**From:** Laura Levitt  
**Sent:** Wed, 20 Jan 2021 13:13:08 +0000  
**To:** Janet Mullen  
**Subject:** 20/04303/APP

The site is within the conservation area and the main house is Grade II listed. The heritage assessment is the impact on the special historic and architectural interest of the listed building, including its setting and the character and appearance of the conservation area. No relevant planning history can be found on file.

Drawing Title: Proposed Garden Store & Studio

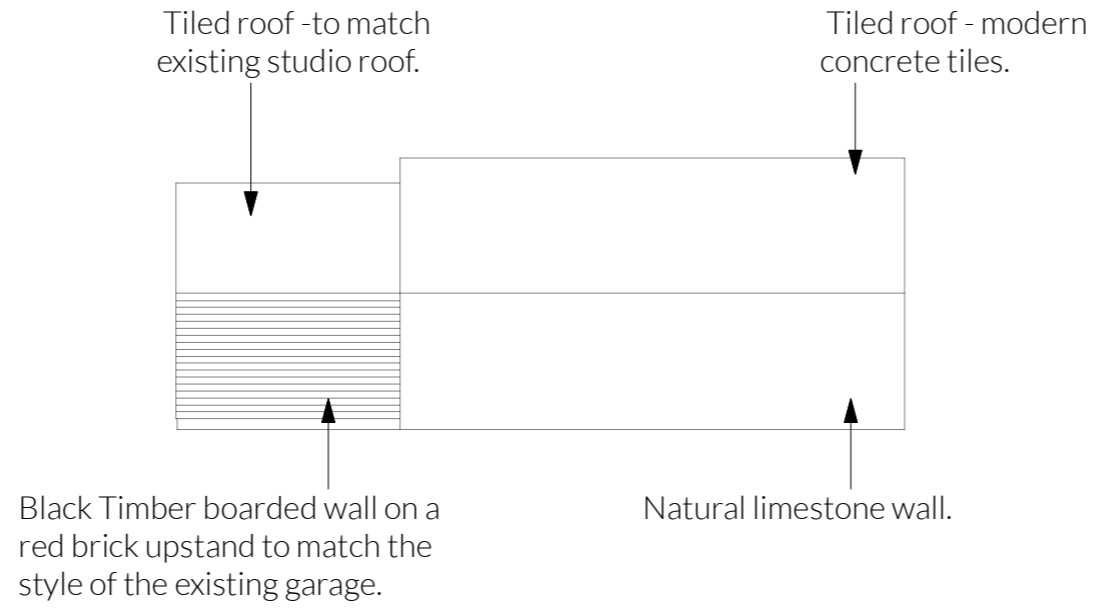
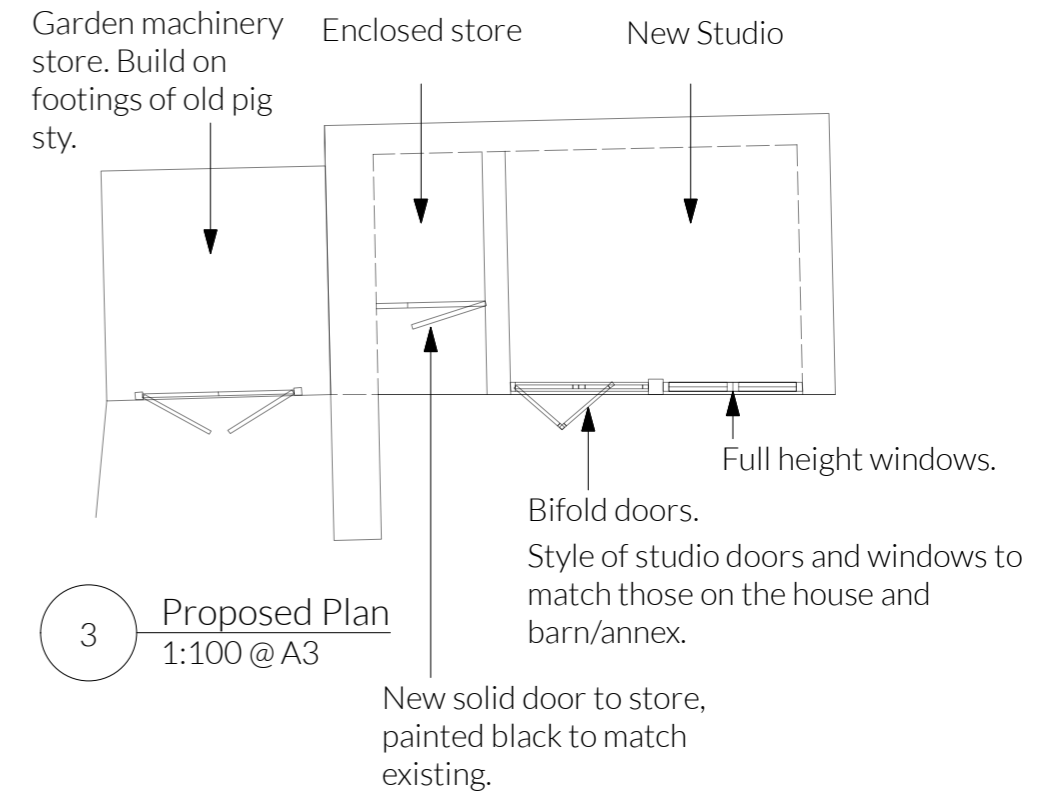
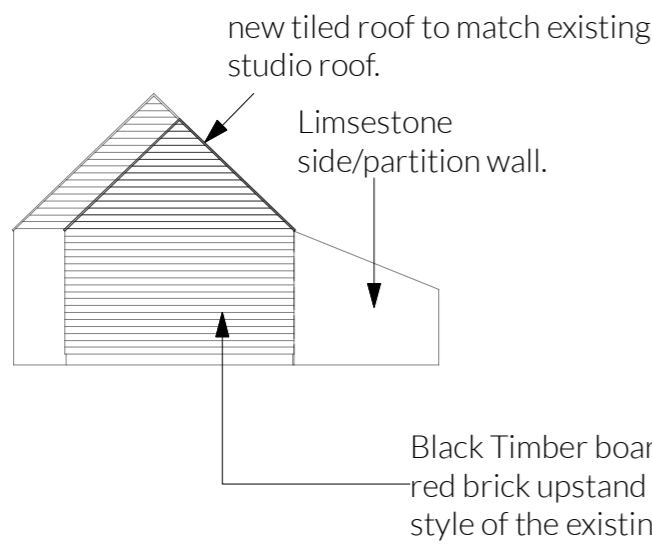
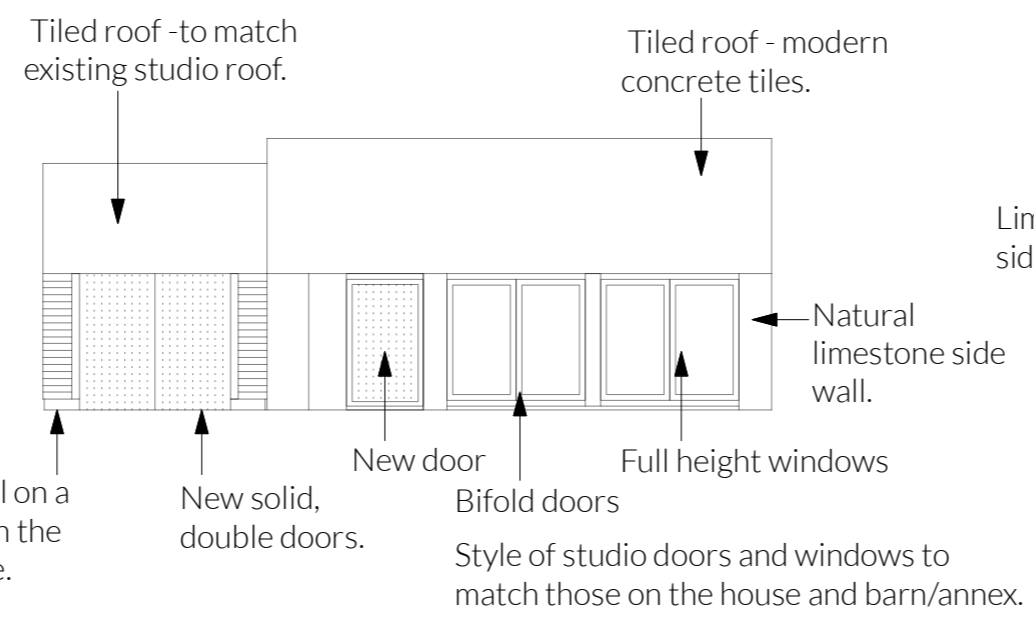
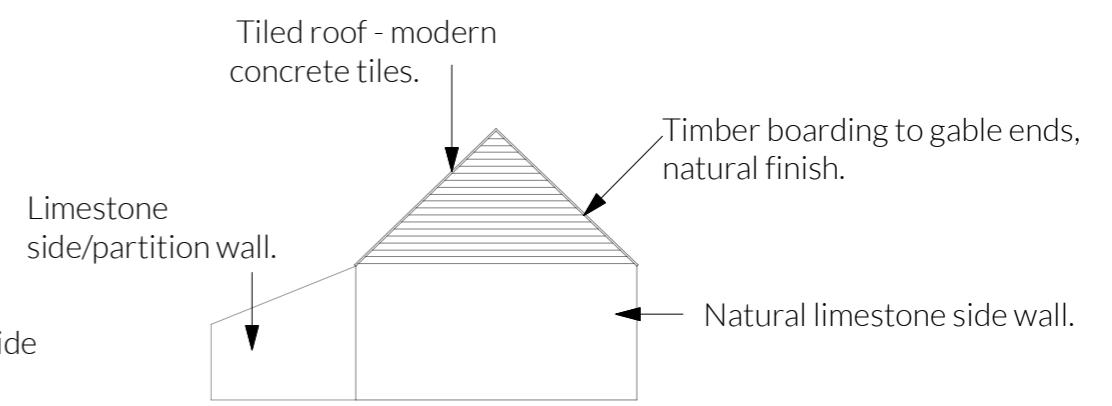
There is no objection to enclosing existing outbuilding as the existing openings would be used; details of the doors may be required by condition. However it is not clear if any repair or internal works are proposed and clarity on this is sought. As to extension of this building, again this is considered acceptable as it would be located away from the listed house and be traditional in form to fit in with the farm character of the site and buildings. Details of materials would be required by condition, ideally the new tiles would be clay rather than concrete as this is a more traditional material.

Drawing Title: Existing garden store

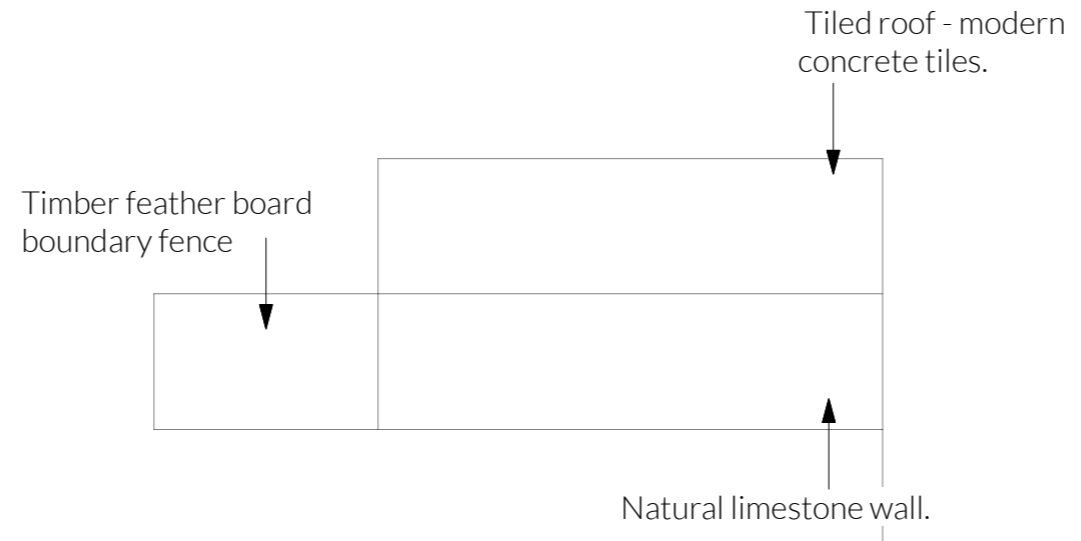
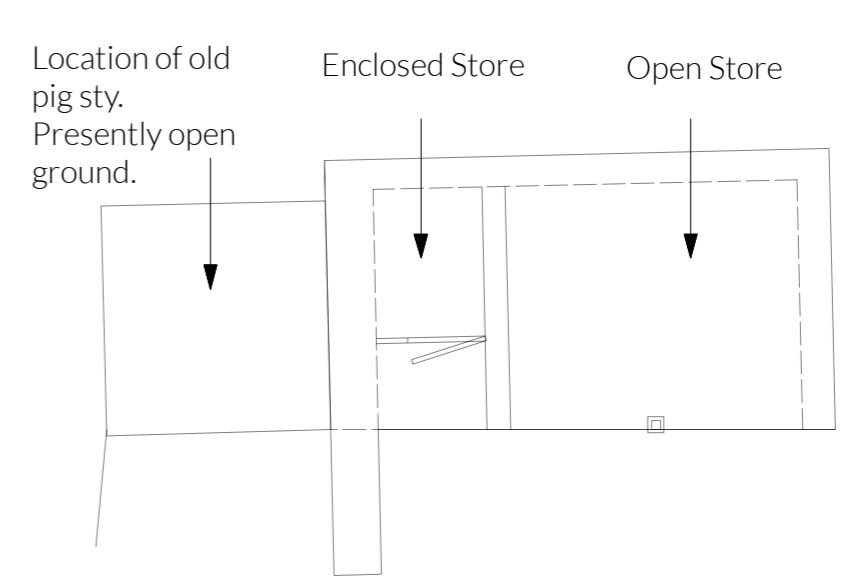
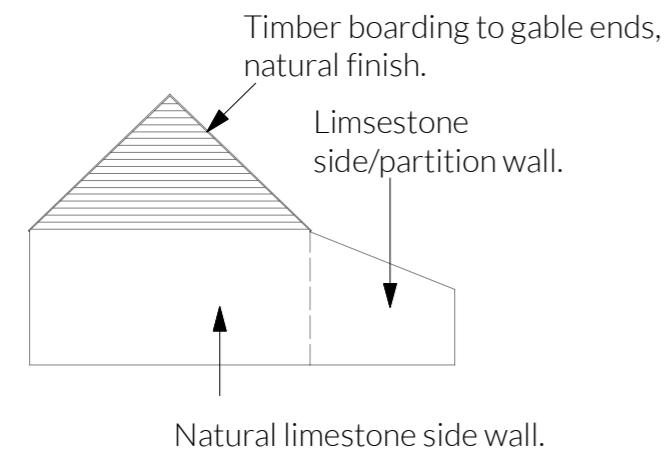
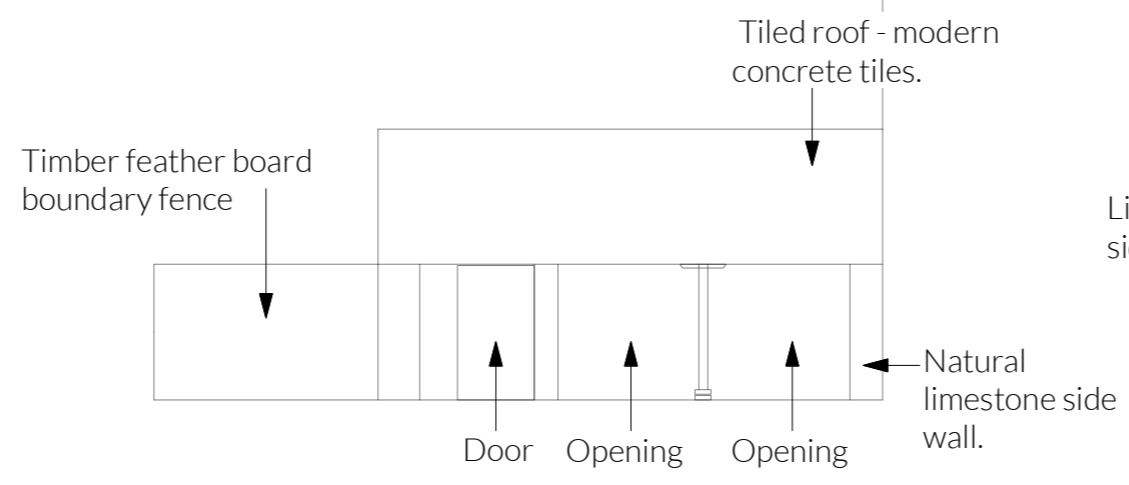
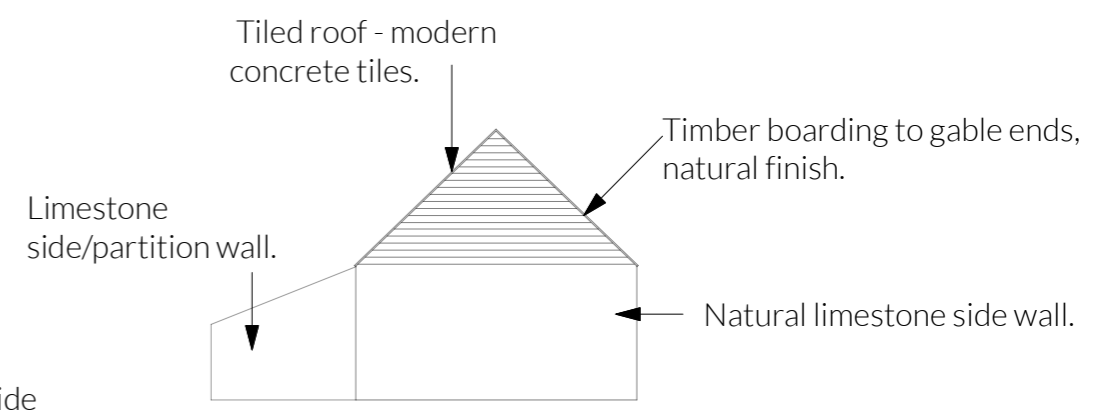
I would like some clarity on the points about the internal and repair works to the outbuilding, clarity of the full extent of the pool works and photos of the areas closer to the main house where changes are proposed to enable fuller assessment of these proposals.

Drawing Title: Pool Proposal

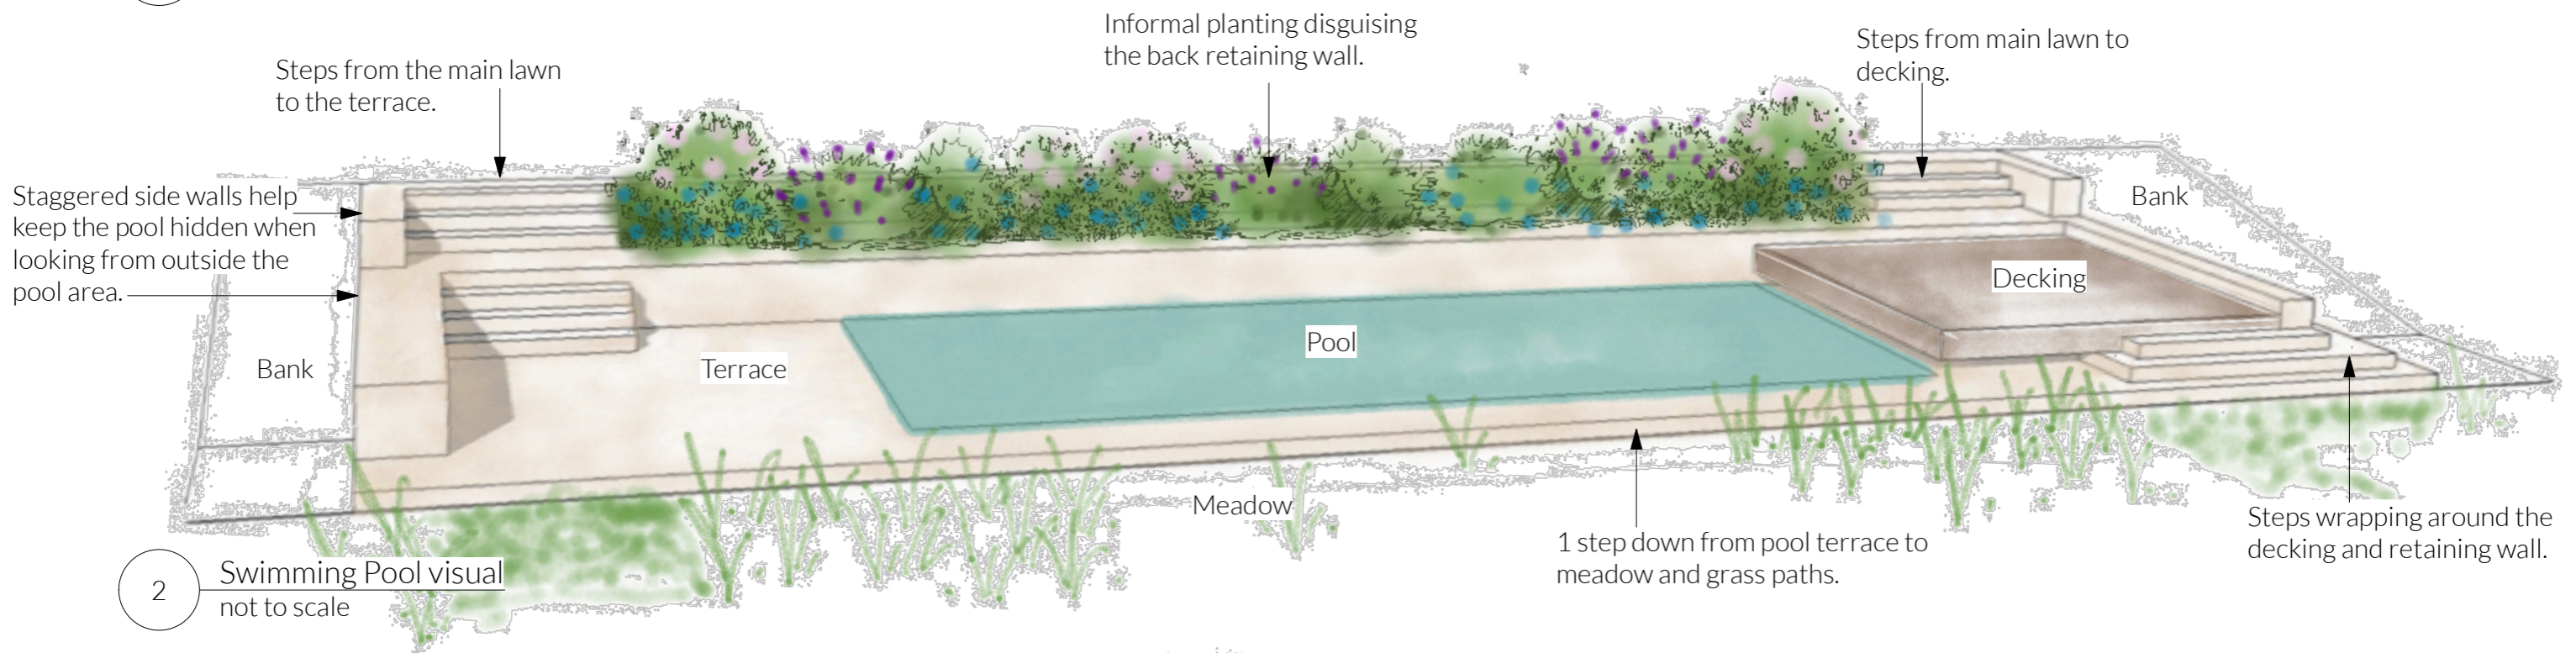
In the case of the pool, as identified in the CA appraisal this is part of the site is 'a private garden that is visible or important private open space', this is shown in the supplied photos as is the agricultural character of the site and the wider area which relates to its history. I accept that the pool, because of the bank would not be seen from the house, however the setting of a listed building is much wider than this and I am concerned that the pool would be visible from view points 3, 4 and 5 submitted and thus would impact on the agricultural setting of the listed building, which is of significance to its history as a farmhouse.

Similarly it would impact on the conservation area, which is also characterised by its landscape quality, due to a pool being a domestic addition and involving hard and manmade construction.

The plans do not make clear how the pool would function, as normally a plant of some kind is required, and so the impact on the heritage assets described could be greater. Furthermore, the assessment on the impact on the setting could also extend to the impact from the noise of filters, the smell of chemicals, as well as the various additions, such as furniture and lighting which could well follow.

In summary, the location of the pool so far from the house, whilst lessening the impact on the views from the listed building, impacts more on the conservation area and the wider setting of

the listed building including views to the listed building. In some ways a suitable position closer to the buildings could be preferable as this would group the domestic elements together, however any detailed discussion on an alternative location should be as part of a pre application service.
